Position Statement from National Highways

Title:	National Highways Update – Deadline 5
Reference:	TR050007
Applicant:	Tritax Symmetry
Proposal:	Application by Tritax Symmetry (Hinckley) Limited for an Order Granting Development Consent for the Hinckley National Rail Freight Interchange
Author:	National Highways (20040073)
Date:	09 February 2024

Table D5.1: Summary of outstanding matters and progress

Drawing file: TR050007 / TR050007-002505-Hinckley NRFI Appendix 14 - Gibbet Hill Mitigation General Arrangement.pdf

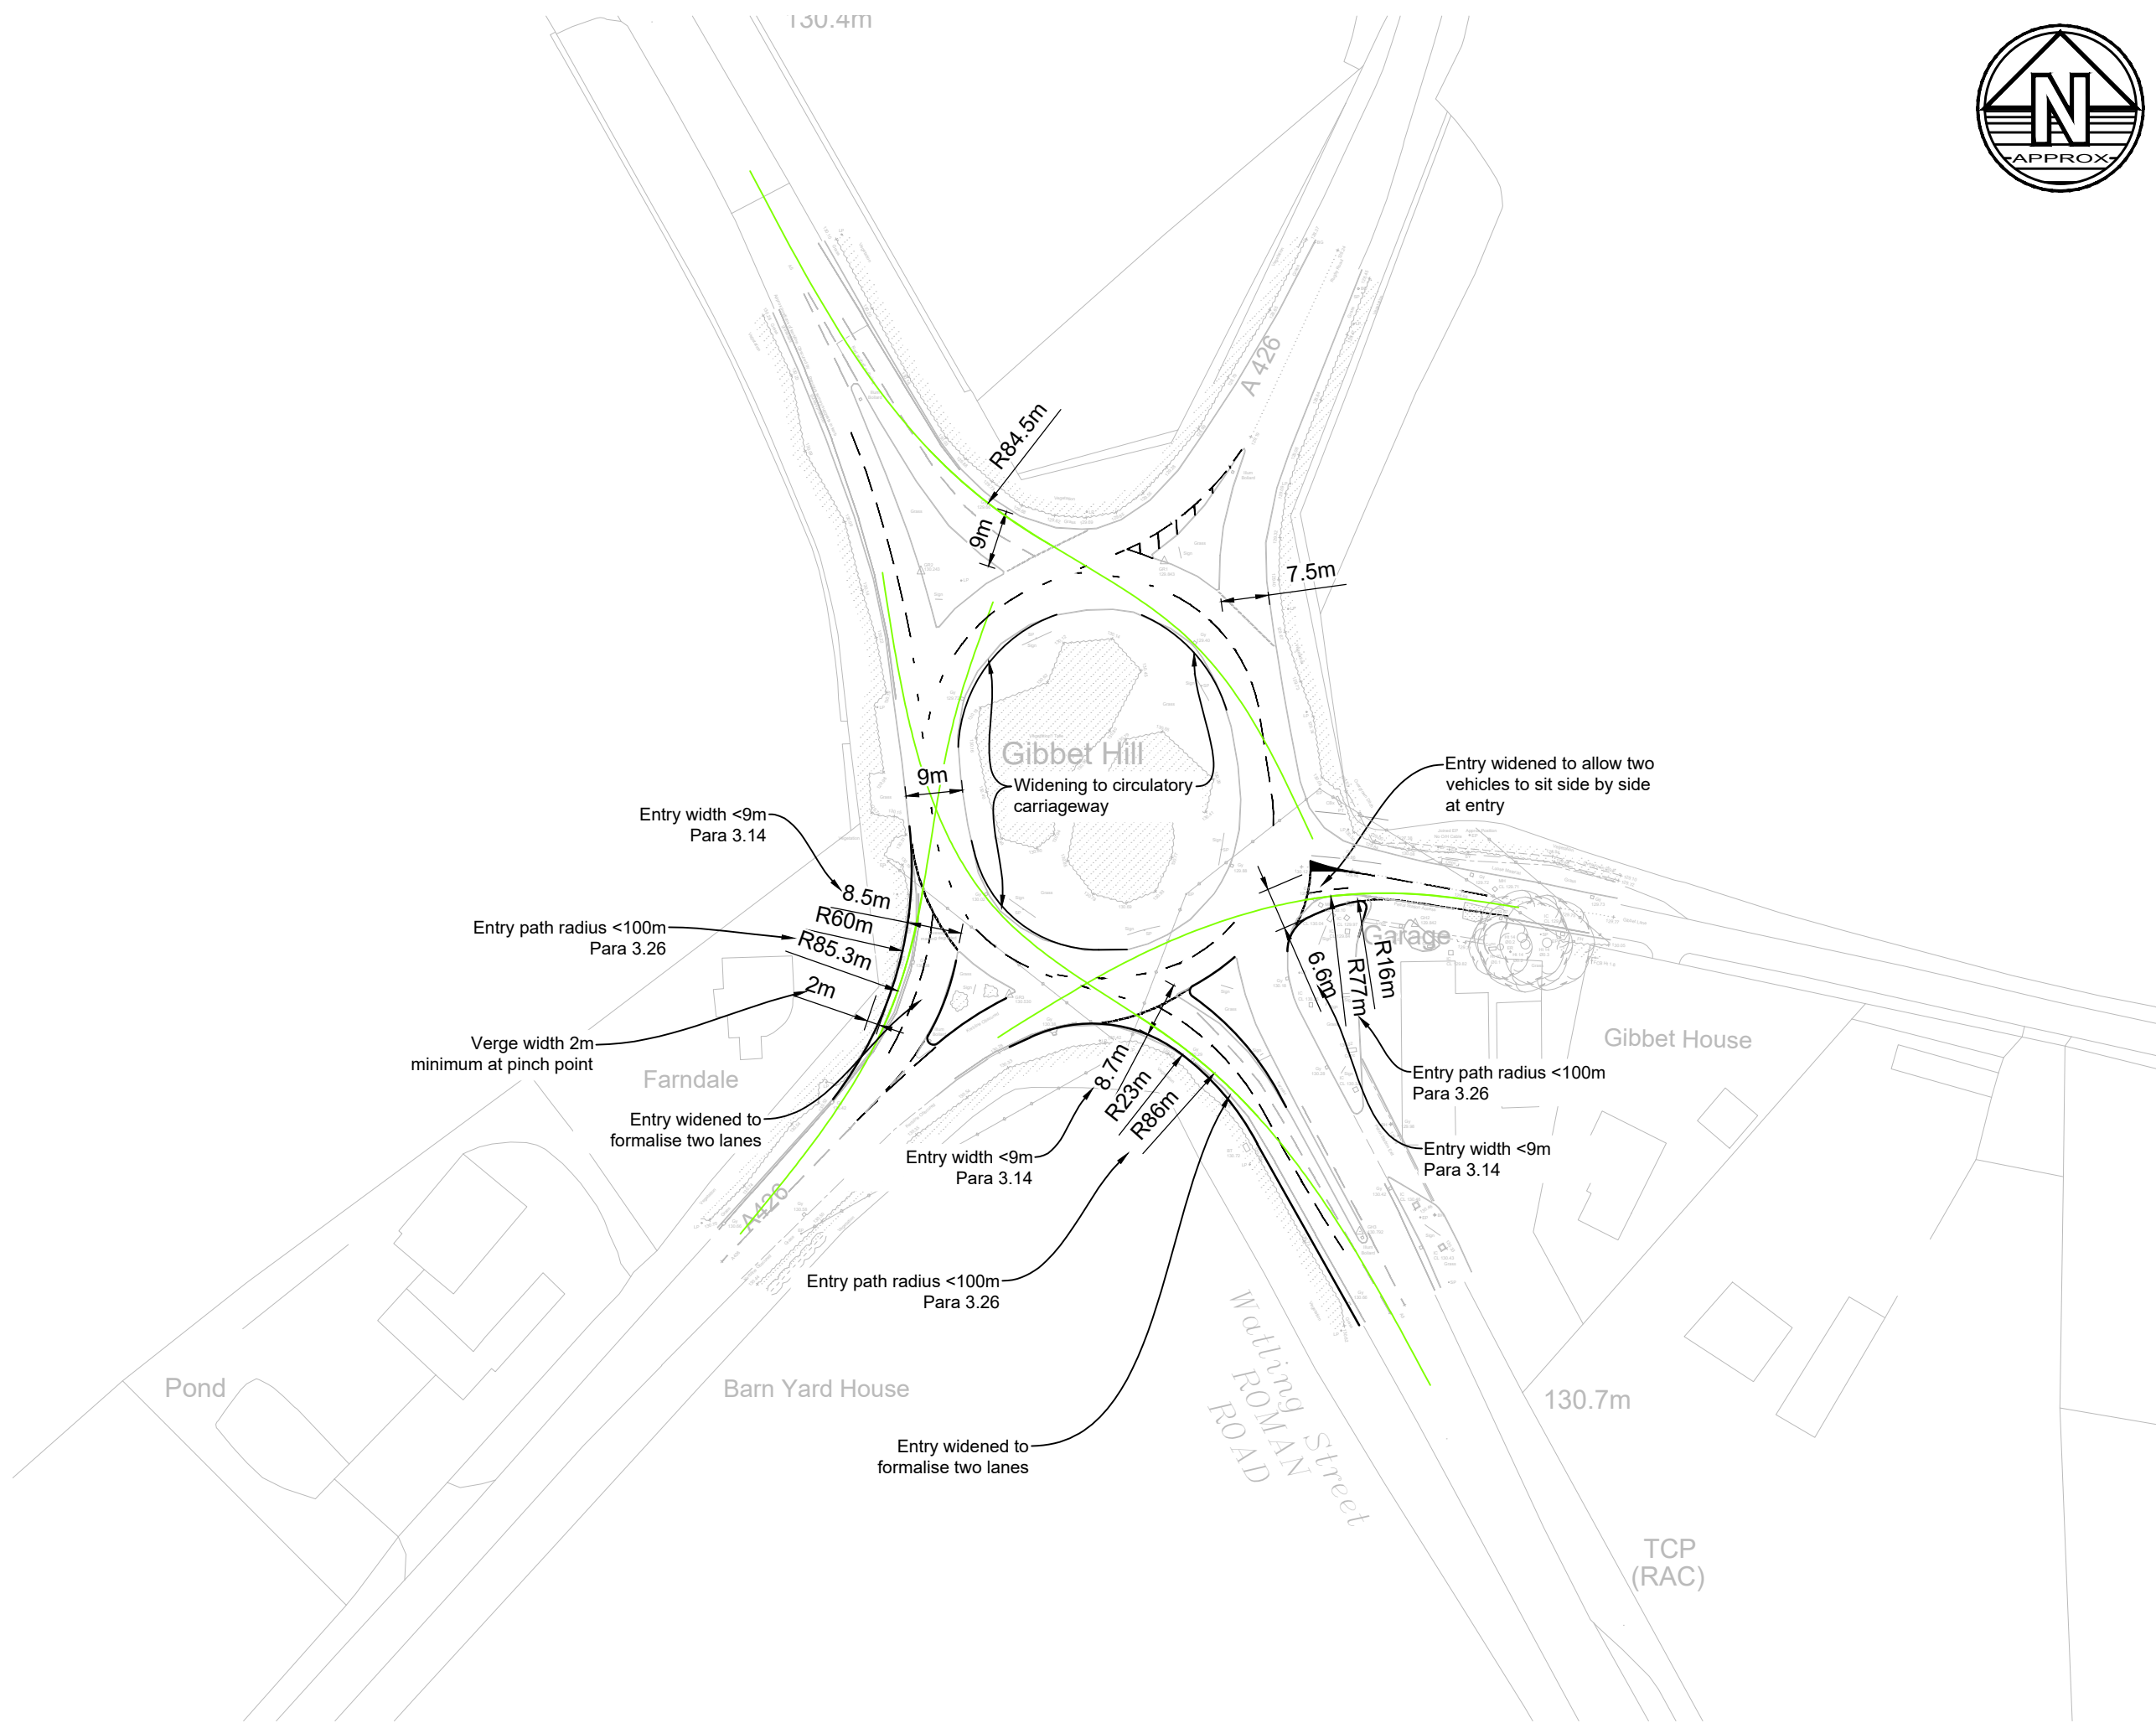
<p><u>Junction 26 – A5 / A426 Gibbet Hill (Existing Layout)</u></p> <p>It has not been possible to verify the roundabout geometry values input into the Existing Layout model without a scaled plan of the junction. This should be provided. Please also supply any traffic flow spreadsheets developed to demonstrate how the traffic flows used in the submitted models have been determined.</p>	<p>A detailed update regarding the review of the Furness process has been provided through the National Highways response to ExQ2.11.1.</p> <p>During the meeting on 2 February, National Highways reiterated our position regarding the assessment requirements in VISSIM as expressed during ISH6. Following the meeting National Highways has confirmed the correct VISSIM model to be utilised.</p>	Ongoing
<p><u>J26 - A5 Gibbet Hill (Proposed Layout)</u></p> <p>The following information is required to enable us to complete our assessment of the submitted LINSIG model.</p> <ul style="list-style-type: none"> – CAD drawings have not been provided so the measurements in the models cannot be checked. – The demand spreadsheets have not been provided so the demands in the model cannot be checked. – The Saturation Flows have been entered manually rather than using LinSig's RR67 calculation. The calculations that resulted in these Saturation Flows have not been provided so cannot be checked. 	<p>At ISH6 it was clarified that National Highways proposals at the Gibbet Hill roundabout are still in development stages. The process advised by LCC, to which WCC and NH have previously agreed on other developments, is for a mitigation scheme to be proposed by the Applicant team to be used as the basis for a contribution in lieu.</p> <p>During the meeting on 2 February, National Highways reiterated our position regarding the assessment requirements in VISSIM as expressed during ISH6. Following the meeting National Highways has confirmed the correct VISSIM model to be utilised.</p> <p>Also at the same meeting, a process was detailed to the Applicant team which would require agreement of the traffic flows (through the ongoing PRTM and furness reviews), the VISSIM model and the proposed mitigation scheme in lieu. It is National Highways understanding that the Applicant team will also provide a breakdown</p>	Ongoing

<p>– Custom lane lengths have not been entered. This isn't necessary incorrect, however, it would depend on the junction's measurement which have not been provided.</p>	<p>of the cost estimate used to derive the proposed contribution value.</p>	
<p><u>Junction 27 – A5 / A4303 / B4027 Coal Pit Lane Roundabout</u></p> <p>Although the proposed layout drawing has been provided within the Transport Assessment, it has not been possible to fully verify the roundabout geometry values input into the Existing and Proposed models due to the extent of the junction shown on the plan. Please can further information be provided to demonstrate how the roundabout geometry has been calculated.</p> <p>National Highways requests the provision of any traffic flow spreadsheets developed to demonstrate how the traffic flows used in the submitted models have been determined.</p>	<p>A further workshop meeting between the applicant's consultants, BWB, and National Highways will be taking place on the 16th November 2023.</p> <p>The traffic flow information which will be utilised is still not agreed until National Highways is satisfied with the furnishing methodology. A detailed update regarding the review of the Furness process has been provided through the National Highways response to ExQ2.11.1.</p>	<p>Ongoing</p>
